WEST SUSSEX COUNTY COUNCIL CONSULTATION

TO:	Arun District Council FAO: Zac Denton
FROM:	WSCC - Highways Authority
DATE:	19 December 2019
LOCATION:	Lyminster Cottage, Lyminster Road, Lyminster, BN17 7QF
SUBJECT:	LY/13/19/HH New entrance/driveway, restoration of external building at the front of the property. Restoration of walled garden, front and rear. Adjustment of levels around the property. Restoration of all windows and small front porch area. Two storey extension including demolition of existing extension. This application may affect the character and appearance of the Lyminster Conservation area.
DATE OF SITE VISIT:	N/A
RECOMMENDATION:	More Information
S106 CONTRIBUTION TOTAL:	N/A

FIG A.

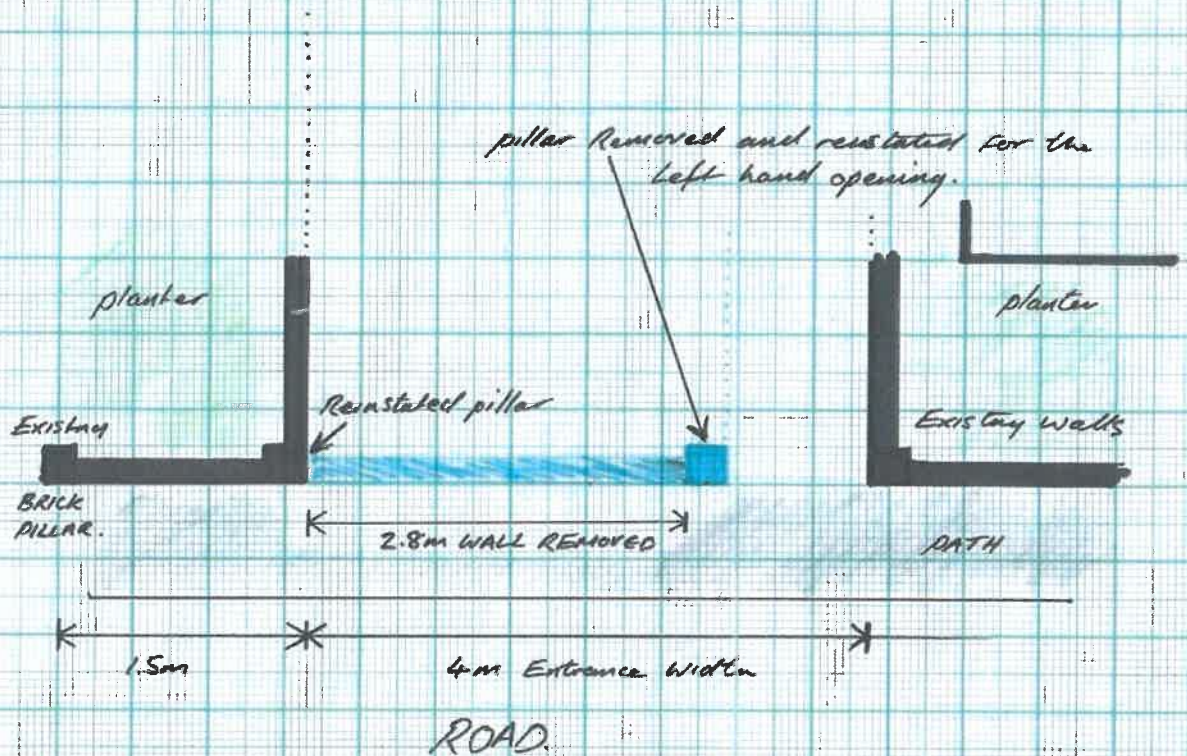
The applicant proposes a new 4m wide vehicular access onto Lyminster Road. Given the application seeks the implementation of new access point onto the maintained highway network the adequacies of the access point, namely geometry and visibility need to be assessed against current guidance and standards. The applicant has not demonstrated visibility from the proposed access. As Lyminster Road is subject to a speed limit of 30 mph in this location, Manual for Streets (MfS) is the appropriate standard (2.4m x 43m). This sets out a minimum stopping sight distance (SSD) of 43m in both directions.

The applicant is requested to provide maximum achievable visibility splays for the proposed access, taken from 2.4m back from the back-edge of the carriageway. The splays must intersect land only within control of the applicant or within the publicly maintained highway and must be drawn to the nearside edge of the carriageway in both directions. The applicant is advised that the front wall may have to be reduced in height to 0.6m in order for these splays to be achievable.

If visibility splays of 43m are not achievable, the applicant can support their reduced splays with a seven-day speed survey.

- Maximum achievable visibility at the proposed access
- Details regarding a reduction in front wall height to 0.6 metres
